From: Lucy Robinson [REDACTED]
Sent: 17 September 2026 09:24
To: Laura Mills
Subject: WA/89/26/NMA - Land West of Yapton Lane, Walberton
Attachments: HTE_Plot 36 Plans and Elevations P4.pdf

I have received through the invalid letter for WA/89/26/NMA for Land West of Yapton Lane in Walberton and just have a couple of comments which I have noted below.

PROJECT TITLE
Land West of Yapton Lane
DRAWING TITLE
PLOTS 12-16 Plans
DRAWING NUMBER
C9_23_38_PL_HTABB_P3

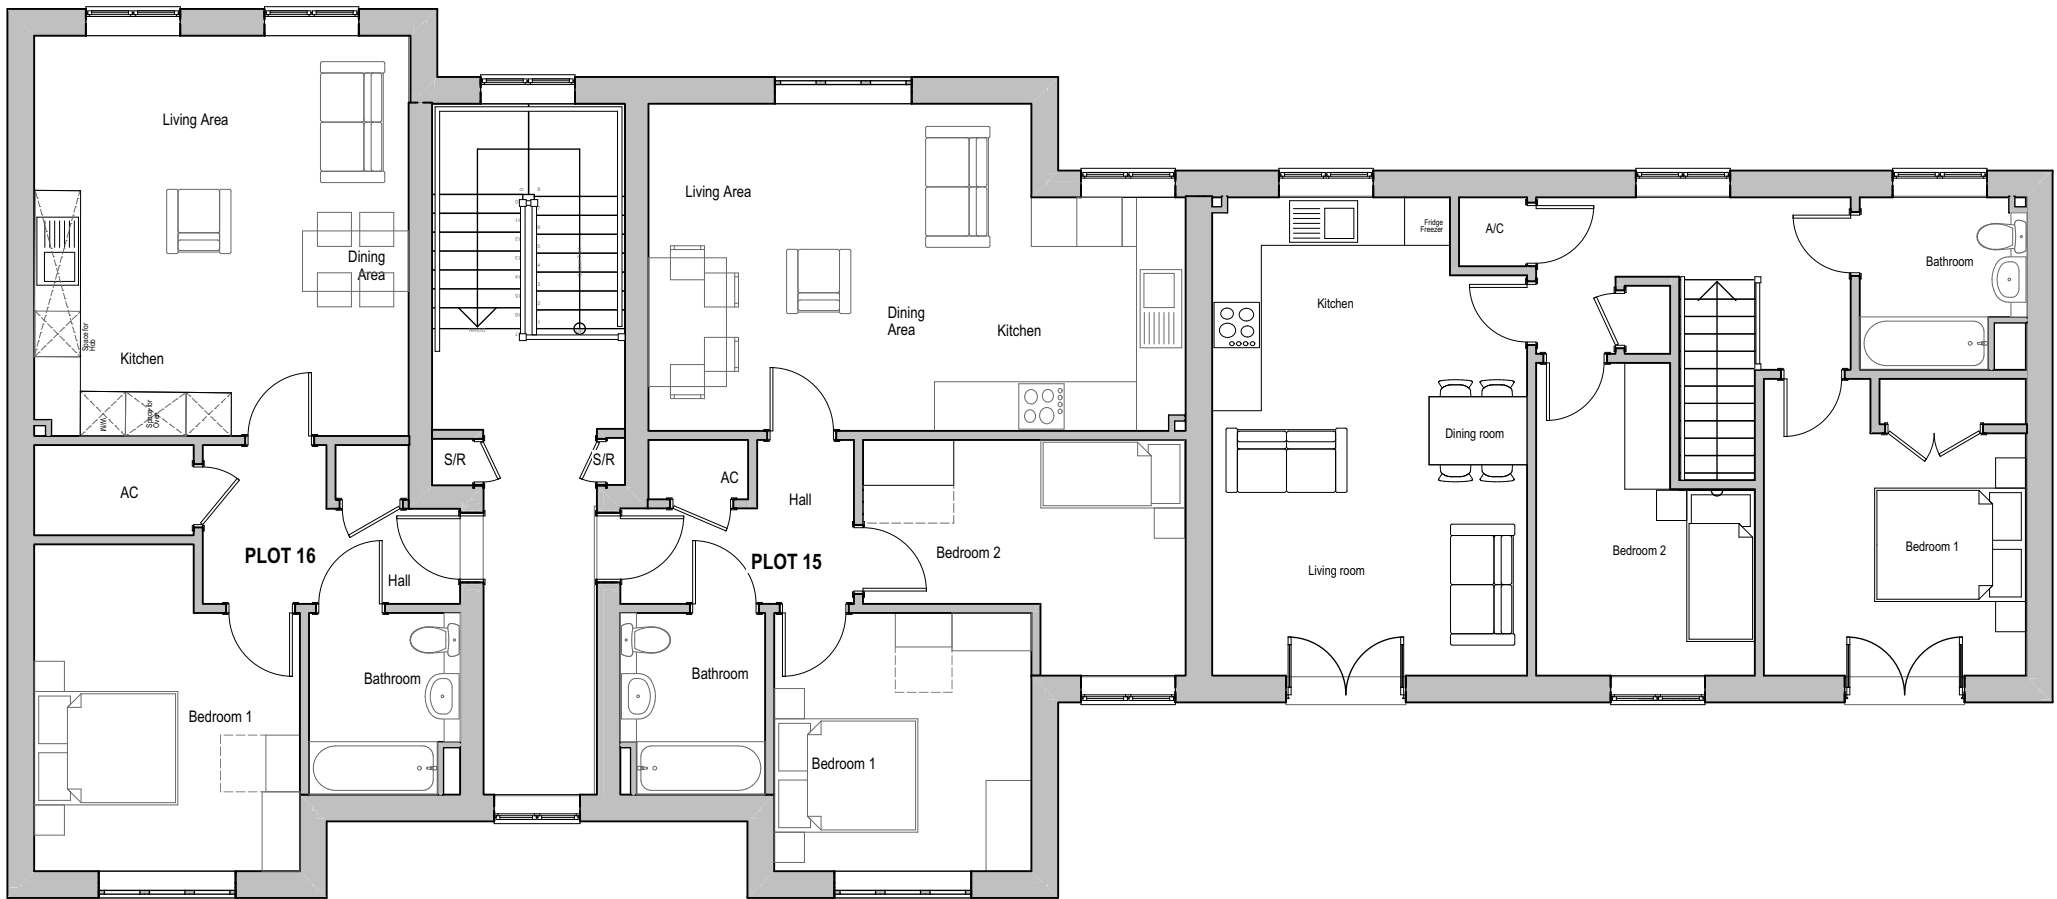
- C9_26_03_PL_HTE_P4 Plot 36 – The front door is shown on the front elevation and is noted as number 14 on the material schedule. I have re-attached this plan for ease.
- C9_23_38_PL_HTABB_P4 Plots 12-16 Elevations – the cycle and refuse stores can be seen on C9_23_38_PL_HTABB_P3 (Plots 12-16 plans). They are located within the internal fabric of the building and thus are not shown on the elevations.
